Application number: 2020/93637	
What is the application for?:	Demolition of clubhouse and erection of detached dwelling with associated extern
Address of the site or building:	Land Adj, 41, Stocks Bank Road, Mirfield, WF14 9QB
Postcode:

Type of comment: An objection

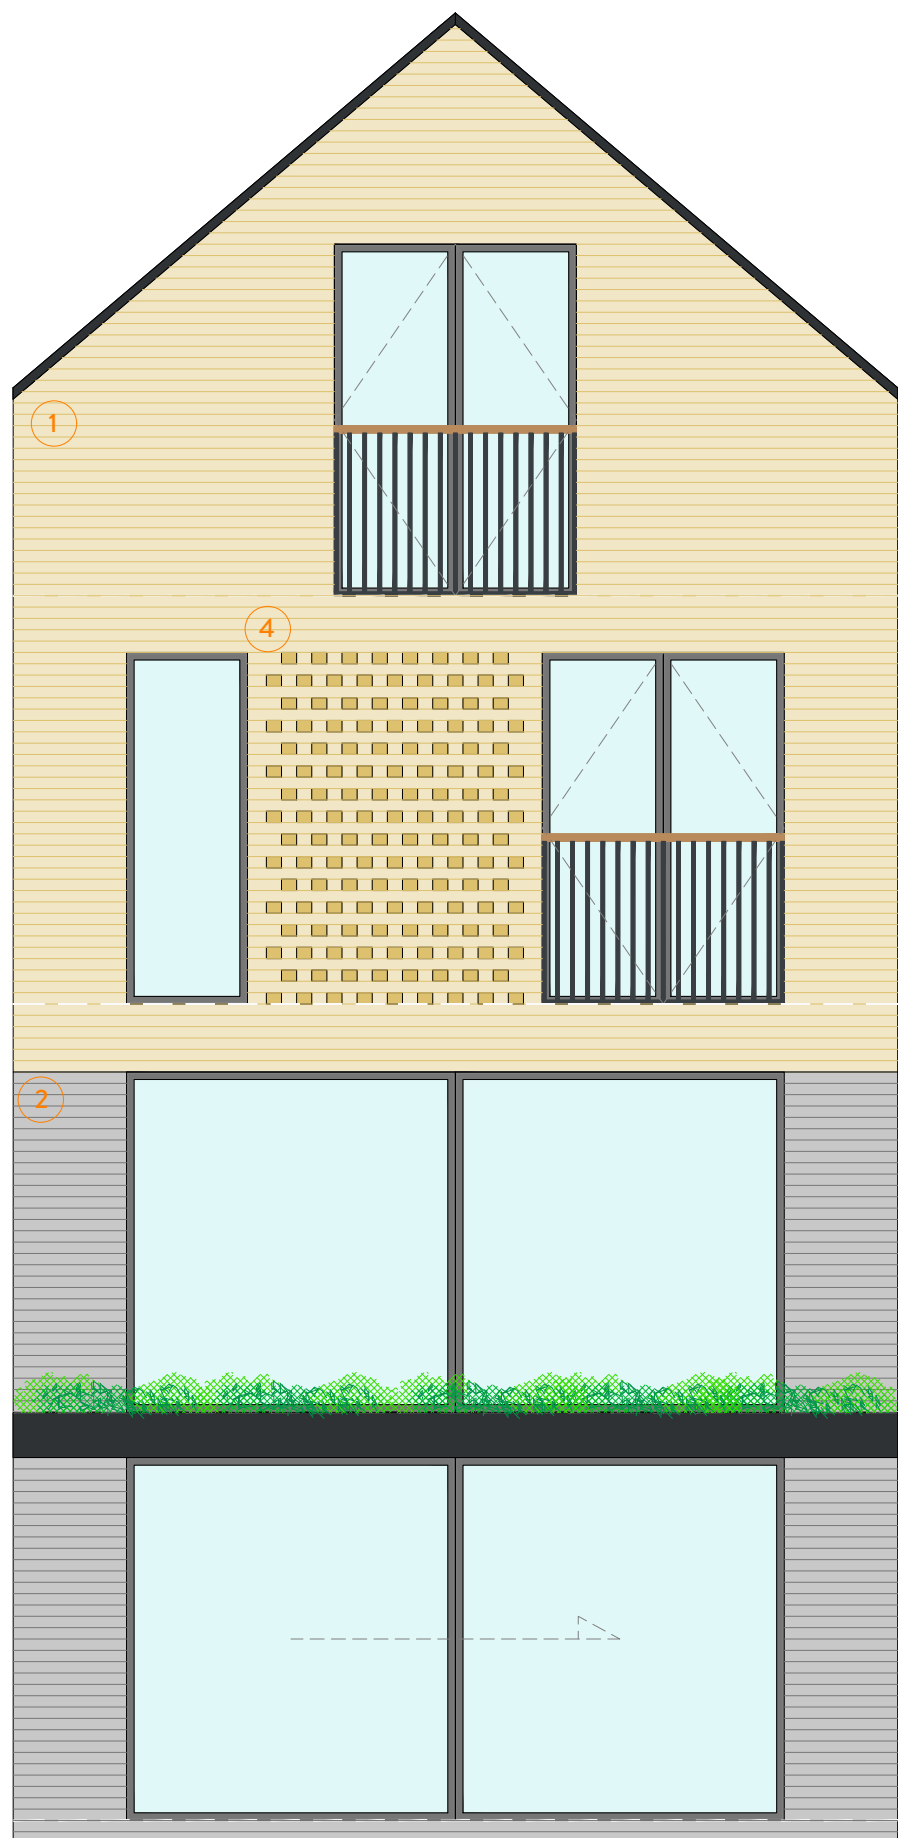
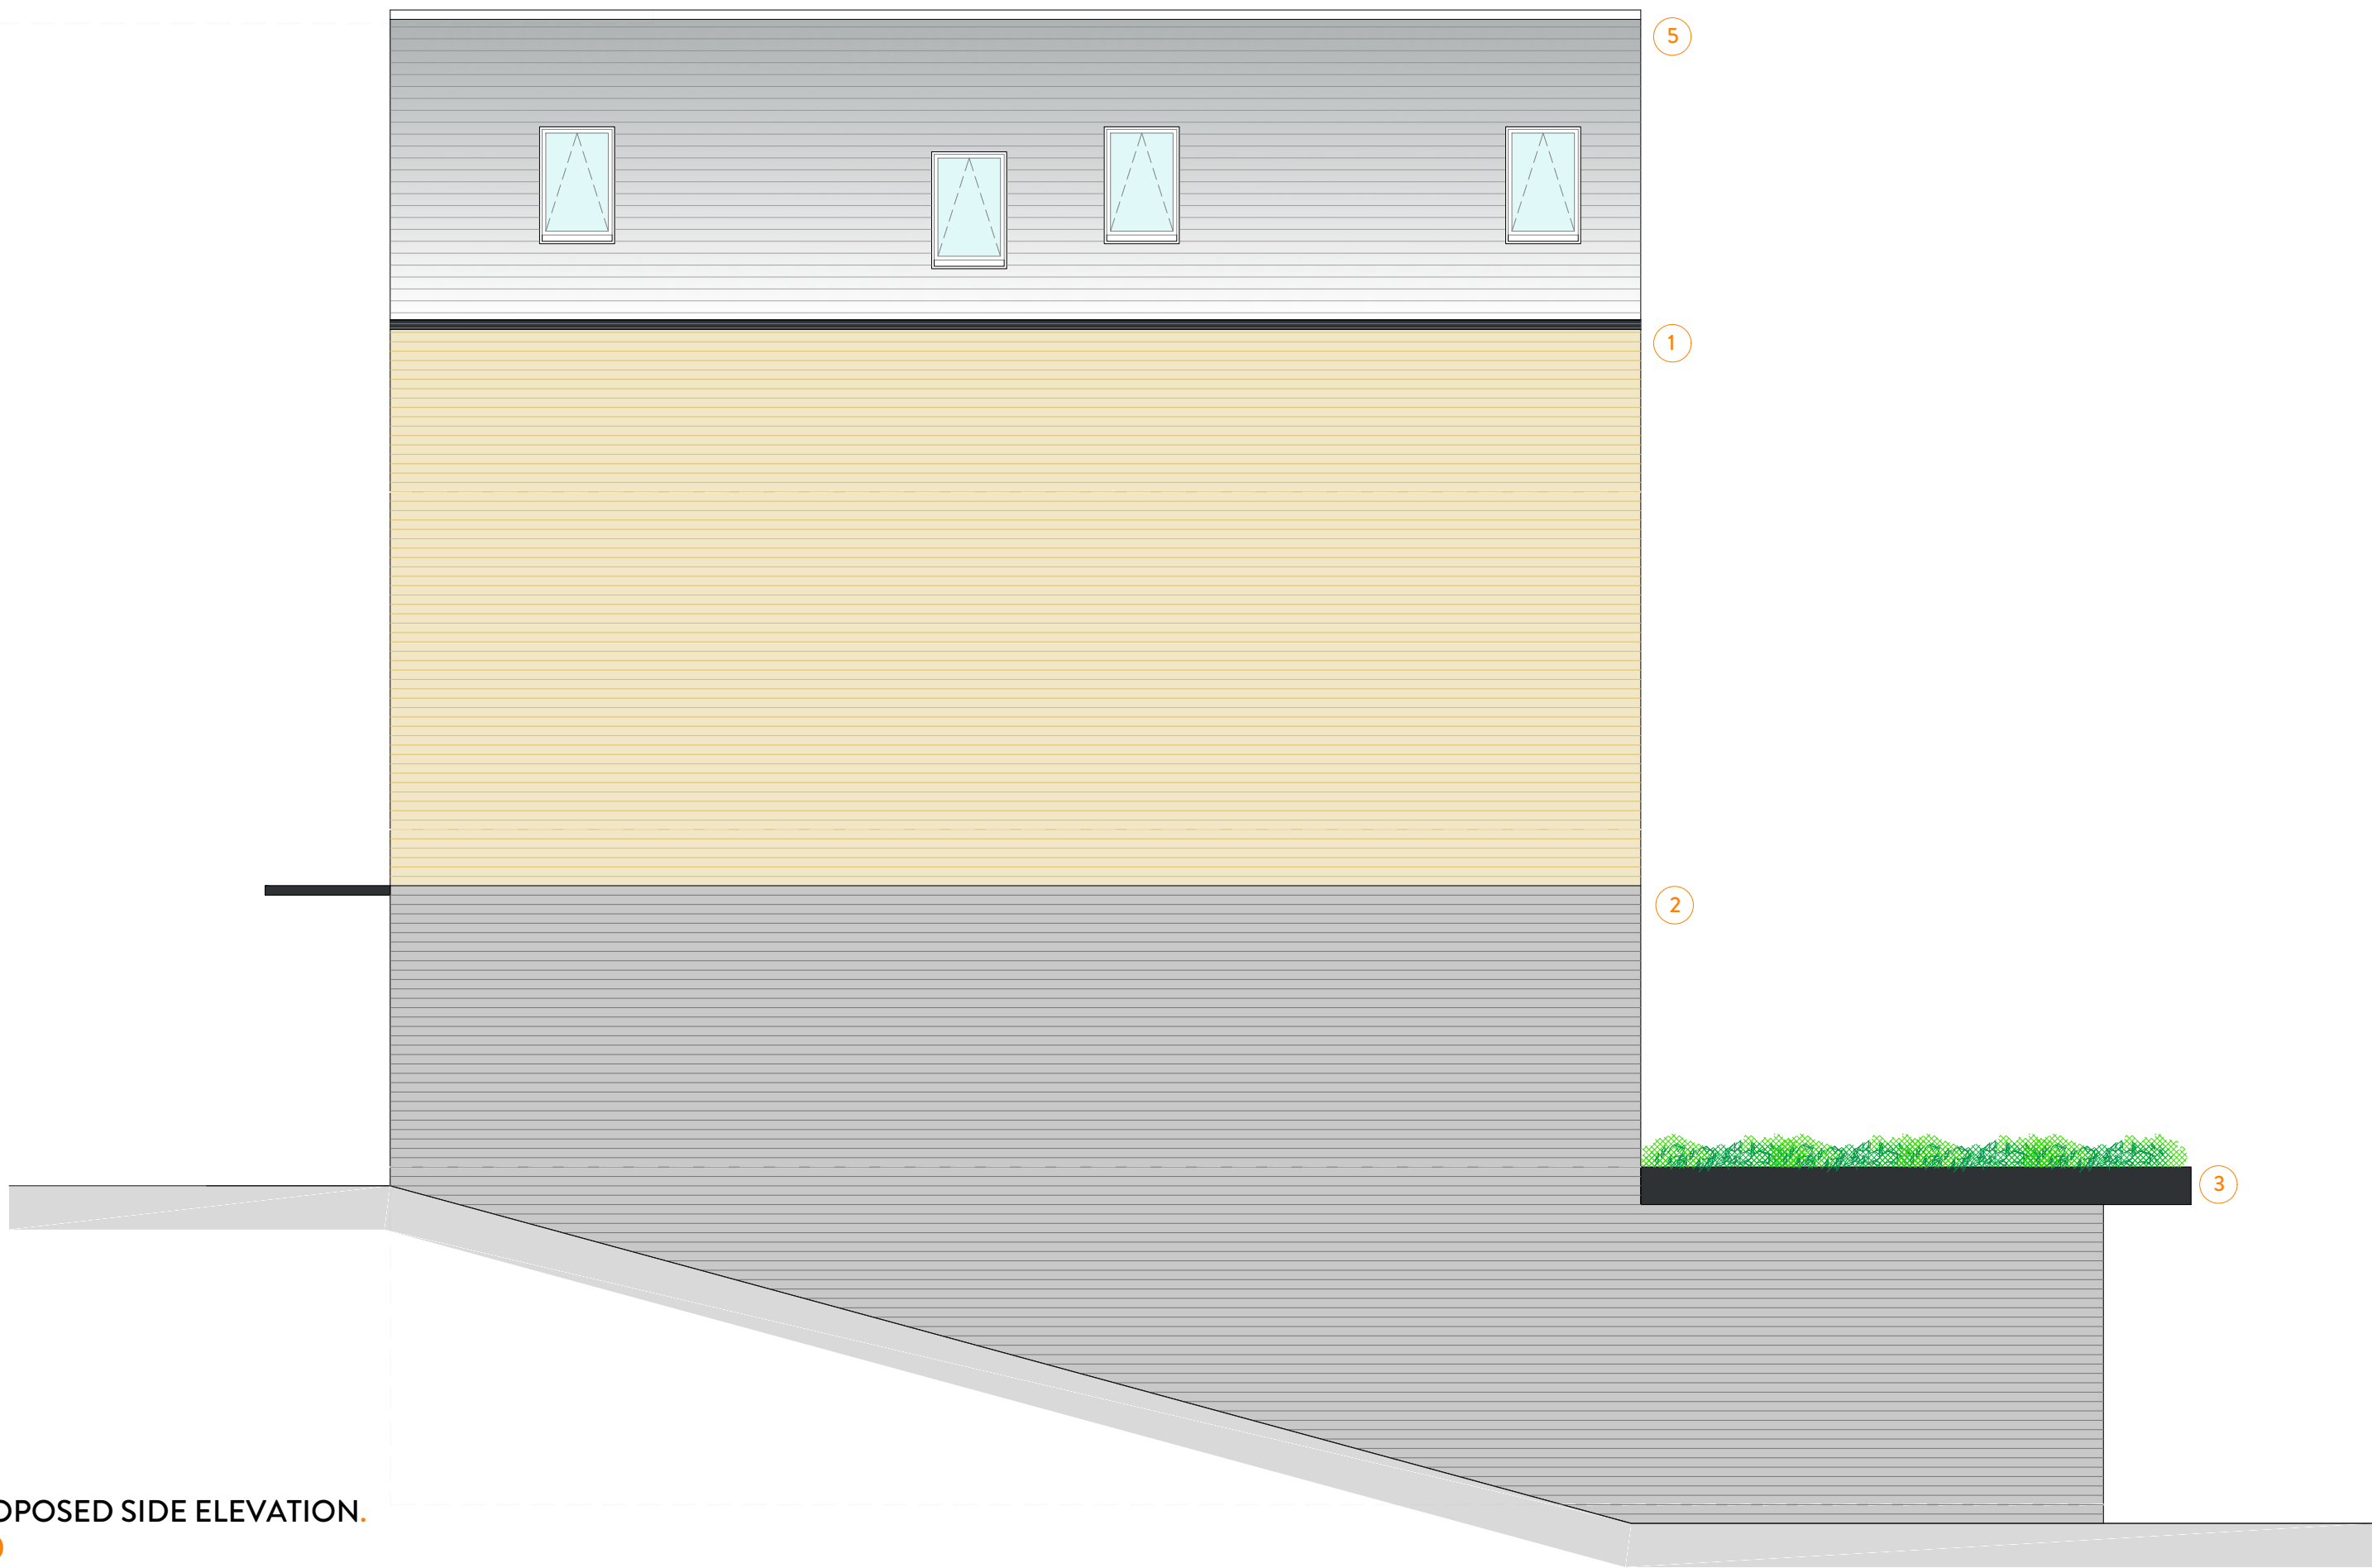
1. No other properties in the area have a ground floor balcony area (first floor really), never mind one this size. Totally unacceptable and cannot be allowed. This is also out of character for the area.

2. Following on from point 1, the sliding doors on the proposed ground floor should therefore be windows and much smaller than the sliding door windows proposed.

3. No other properties have a 4th floor terrace. Again, out of character, cannot be approved.
4. The proposal overlooks properties and impacts their privacy, particularly 2 properties.
